Case ref: EN0110014

### **Application by East Pye Solar Ltd for an order granting development consent for the East Pye Solar project**

#### **Advice following issue of decision to accept the application for examination**

Key Diagram:

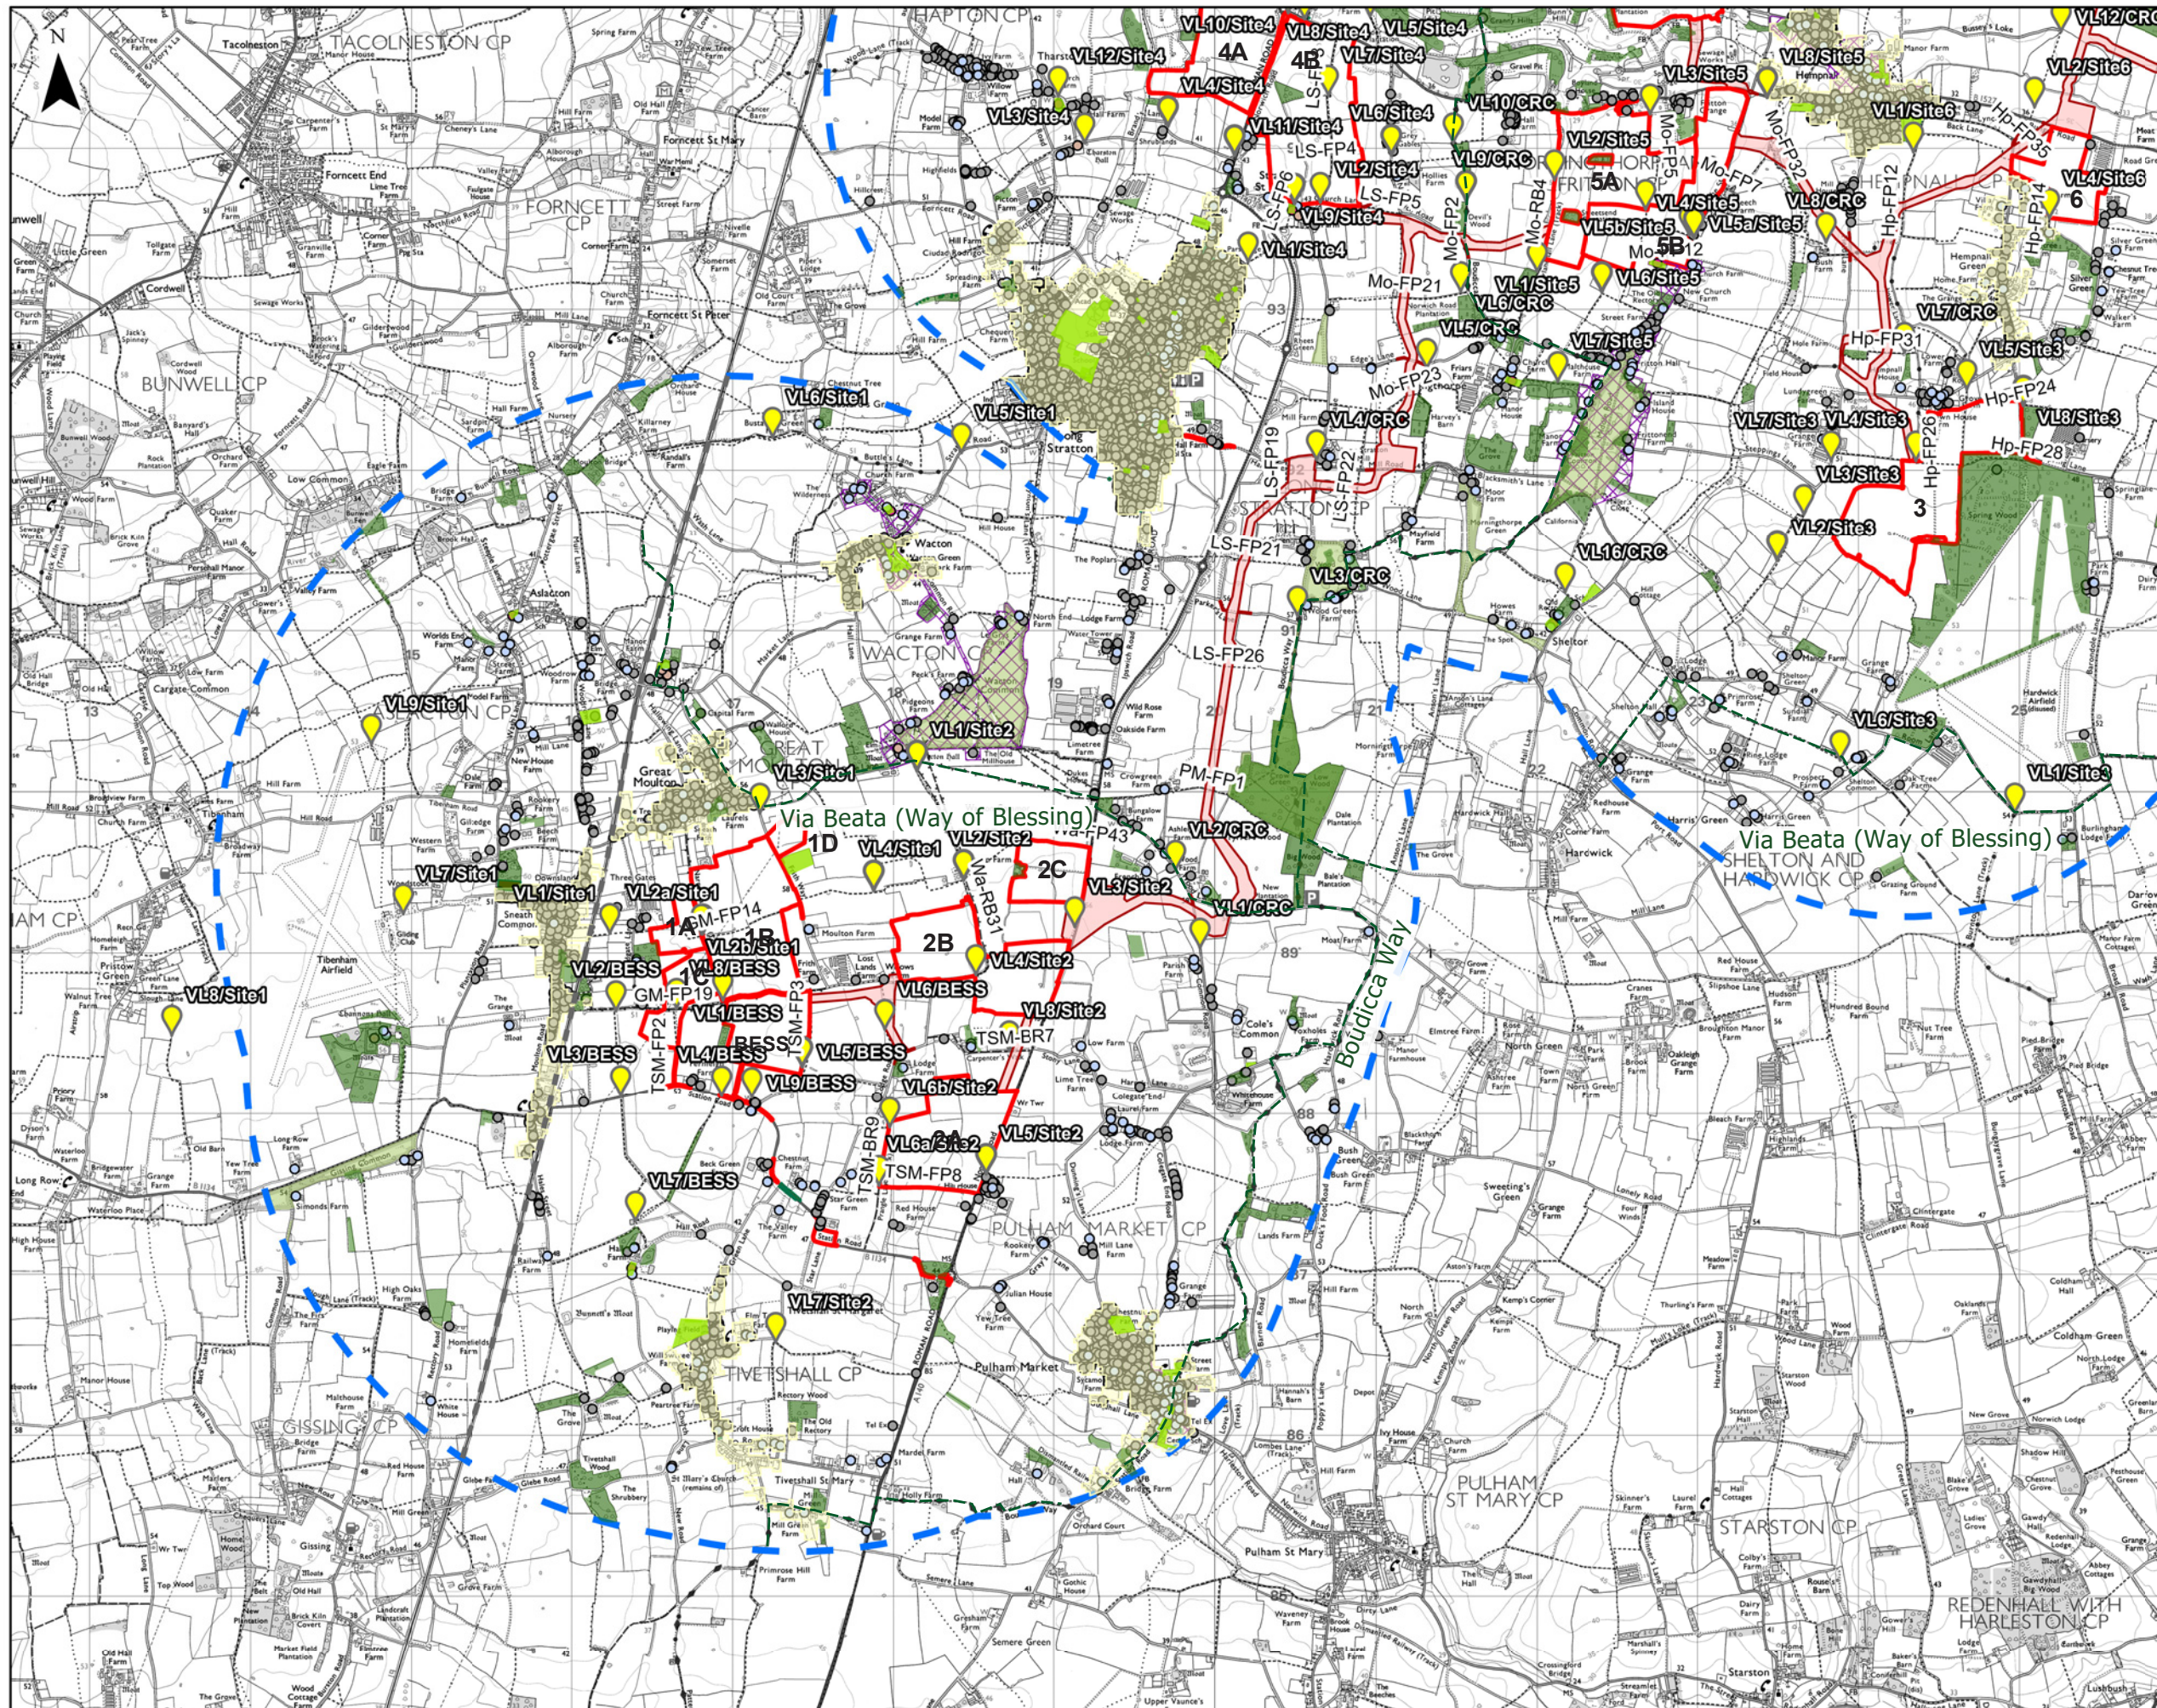
During the acceptance process, issues arose with the downloading and rendering when multiple plans and appendices were opened simultaneously. When a document has a relatively large file size, it can cause difficulties when being viewed on a computer screen. Partial or slow loading issues, and lengthy opening times were experienced by the Planning Inspectorate during the acceptance period. These issues are also likely to be encountered by interested parties, affected persons, the Examining Authority, and others during the examination.

The applicant is expected to manage document size. The applicant is asked to submit revised Volume 2 and 6 documents that eliminate rendering issues and allow multiple files to be opened concurrently. This applies to several figures (such as documents 6.2.5.4, 6.2.7.5 (10), 6.2.7.6, 6.2.7.7, and 6.2.15.1), which range in size from 42.5 MB to 90.8 MB, plan document numbers 2.3 (69 MB) and 2.12 (78.1 MB), as well as to appendices attached to Environmental Statement chapters, such as document 06.03.18.01, which is 145.9 MB.
